Statement of Common Ground with Beverley and North Holderness Internal Drainage Board

Revision 4

December 2025

Figure 3.1 : Indicative Operational Layout Plan

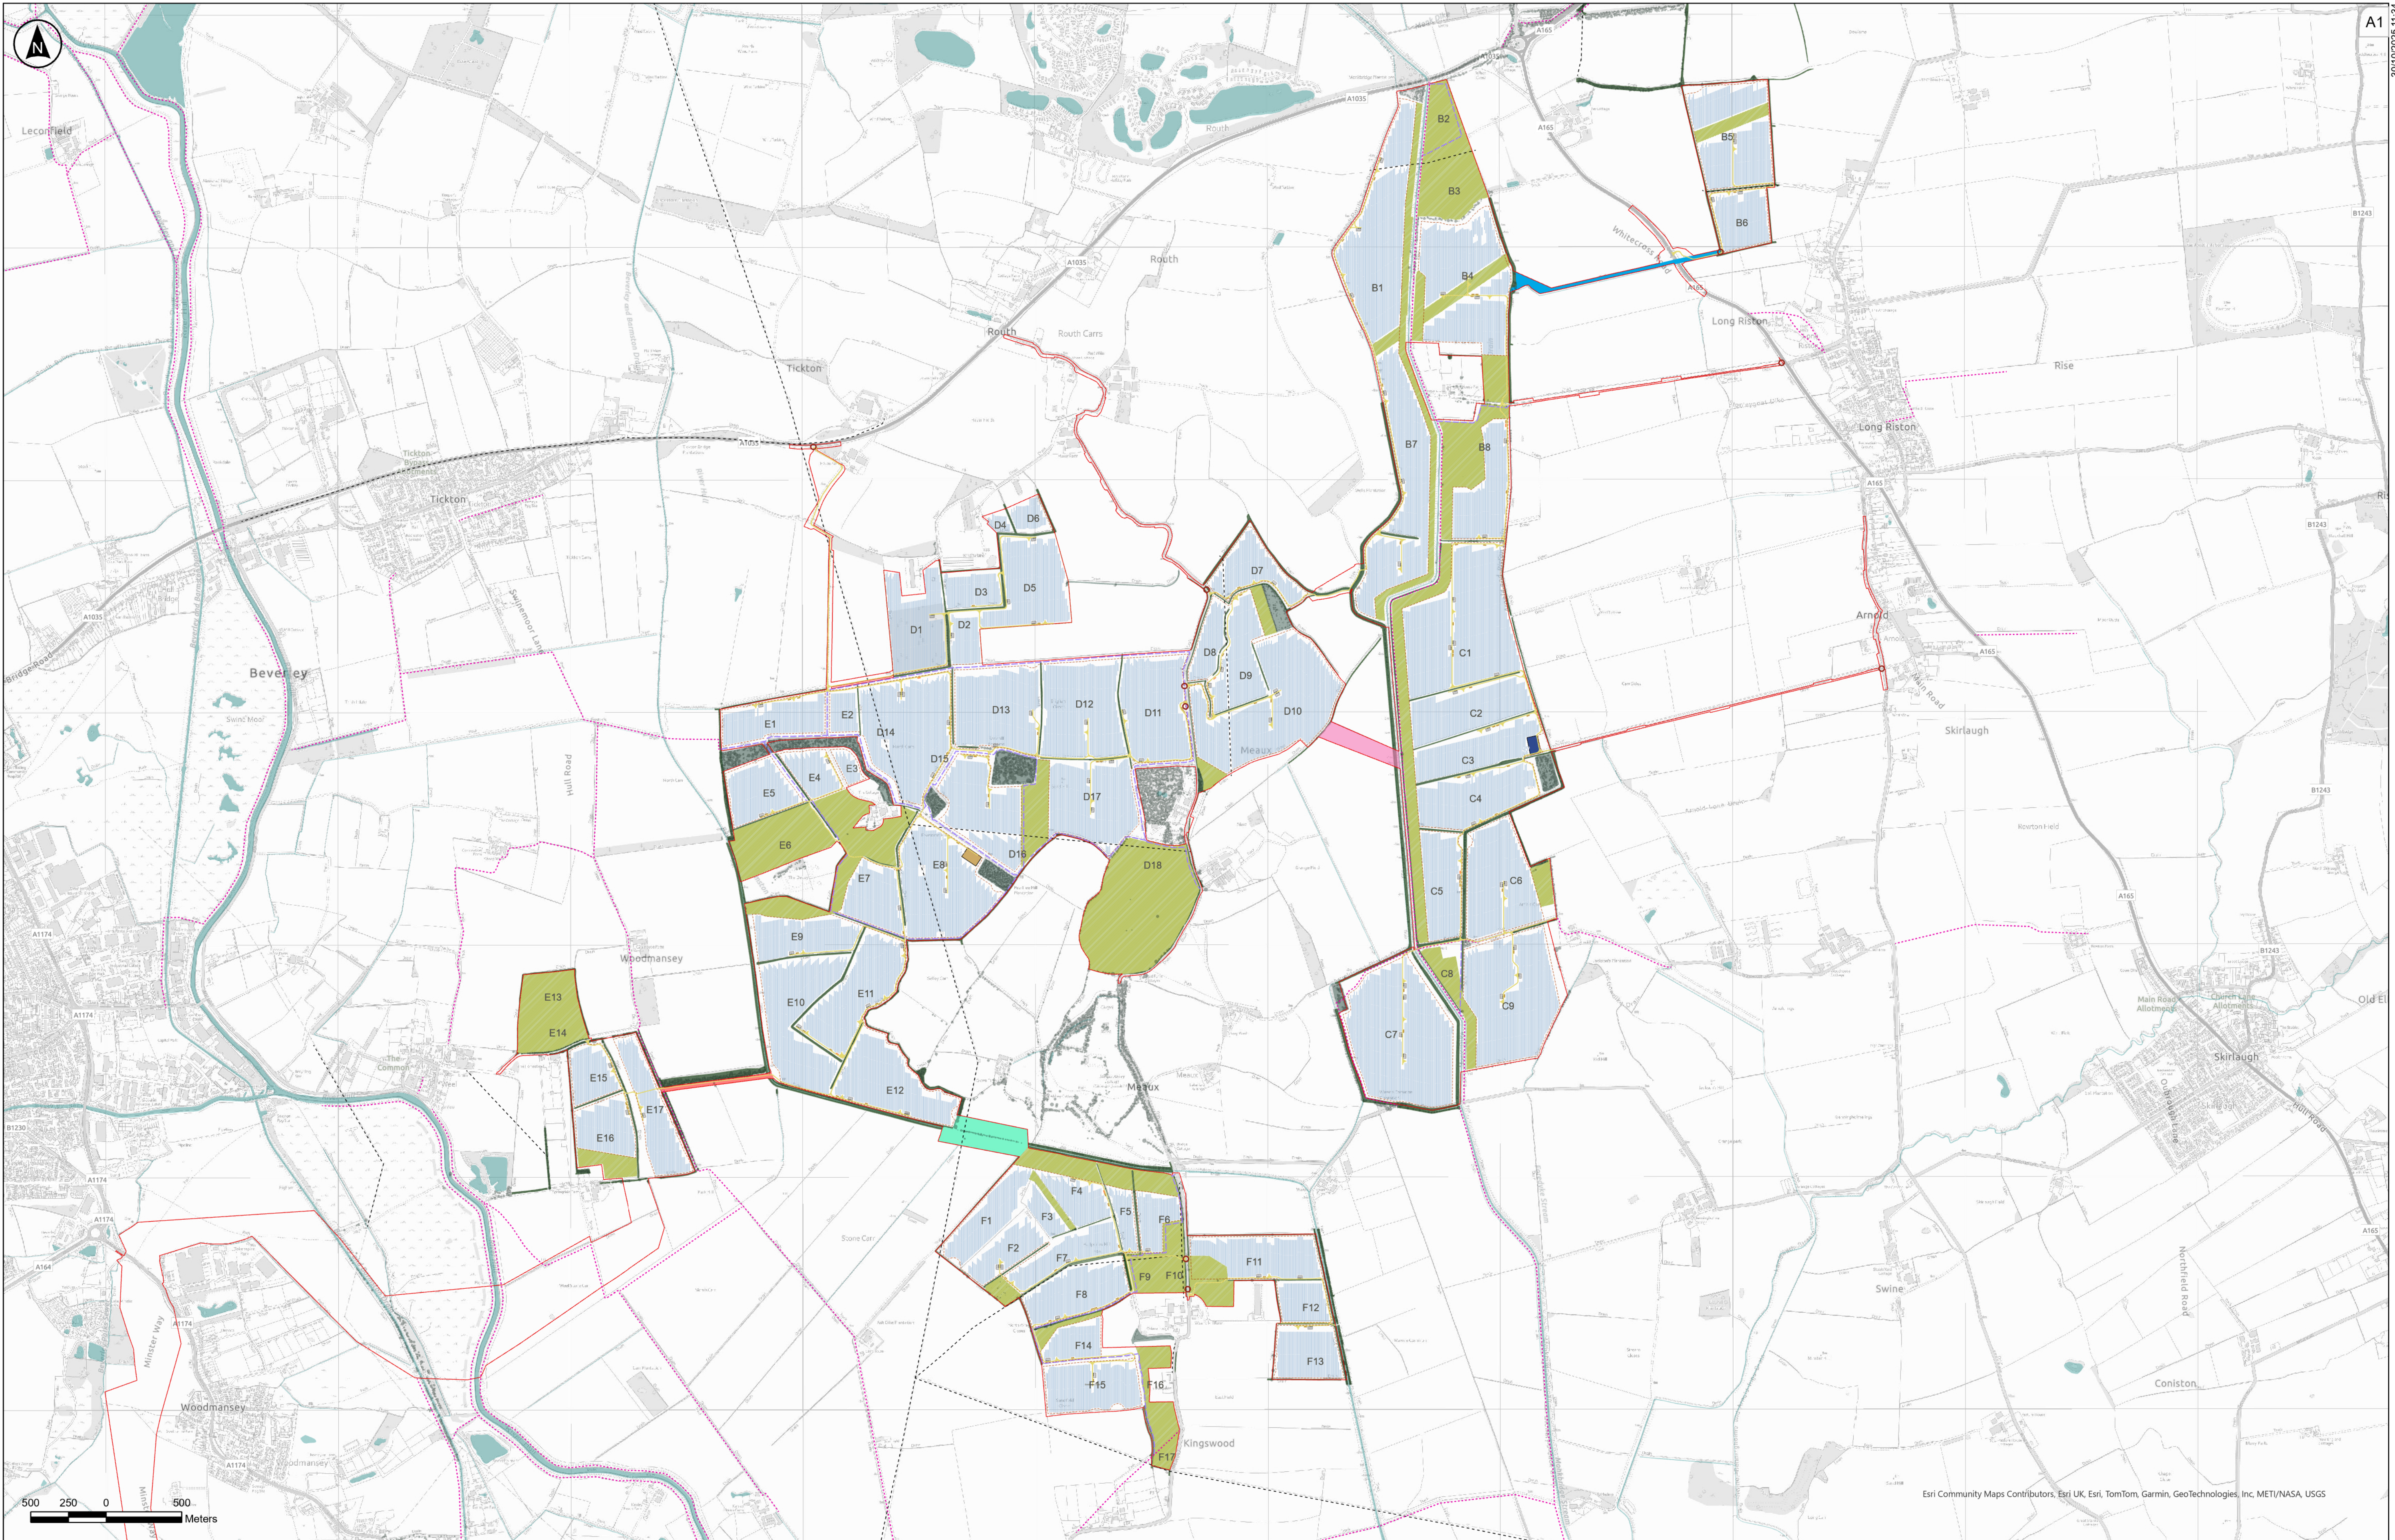
Ref	Topic	Beverley and North Holderness Internal Drainage Board Position	Applicant's Position	Status
	strategy – solar panels <i>Hydrology and Flood Risk</i>	Holderness Internal Drainage Board confirms it will not request a drainage strategy for the solar panels themselves on the basis that there must be a greenfield buffer area of 9m from the bank top of a Board-maintained watercourse and to an ordinary (non-Board maintained) watercourse, and that the area underneath the solar panels must have continuous grass/vegetation all year round.	Management Plan [EN010157/APP/7.5 Revision 3] , the design of the Proposed Development includes a minimum 10m offset from all watercourses (other than locations where span bridges are required to be installed or where existing crossing points or culverts require upgrading) and the solar PV modules would have grass beneath them year-round.	
IDB07	Surface water drainage strategy – inverters, substations, compounds <i>Hydrology and Flood Risk</i>	It was originally agreed with East Riding of Yorkshire Council (Local Lead Flood Authority) and the Beverley and North Holderness Internal Drainage Board in an online meeting on 6 June 2024 that there would be no positive drainage. Instead, rainwater would be directed to ground as per the existing Site response to rainfall. However, in an email dated 26 June 2025 and in its relevant representation [RR-004] , Beverley	The Applicant welcomes this response. The concept drainage strategy is presented within ES Volume 4, Appendix 5.6: Flood Risk Assessment [REP5-030 to REP5-046] . This includes a formal drainage strategy (with positive drainage) for the substation hardstanding areas. The Applicant proposes to drain the proposed hybrid pack areas to ground, mimicking the existing Site response to rainfall. The exception is where there are more than two hybrid packs in a field (field as defined by 'Field Reference' in ES Volume 3, Figure 3.1: Indicative Operational Layout Plan [REP5-023]). Where more than two hybrid packs are proposed, each hybrid pack would be	Agreed

Ref	Topic	Beverley and North Holderness Internal Drainage Board Position	Applicant's Position	Status
		and North Holderness Internal Drainage Board has since requested a formal drainage strategy for impermeable areas over 50m². The Board confirmed via email on 3 December 2025 that it is satisfied with the Applicant's amended approach to surface water drainage.	positively drained with discharge from each one being no more than 1 litre per second. Discharge would be directly to a watercourse or, where this is not feasible, to an existing land drain.	
IDB08	Scoping out Water as a chapter in the ES <i>Approach to EIA</i>	The Board confirmed via email on 1 September 2025 that it has no objection to the Applicant's approach of scoping out Water as a standalone ES chapter.	The Applicant welcomes this response. The Applicant reached agreement with the Environment Agency prior to submission of the DCO Application that surface water and flood risk would be scoped out of the ES as a standalone Water chapter on the basis that ES Volume 4, Appendix 5.6: Flood Risk Assessment [APP-102] (which demonstrates no significant impact) and ES Volume 4, Appendix 5.5: Water Framework Directive Screening and Scoping Report [APP-101] were submitted in support of the DCO Application, with groundwater quality remaining scoped into ES Volume 2, Chapter 10: Land, Soils and Groundwater [APP-046]. Further explanation of the approach is provided within ES	Agreed
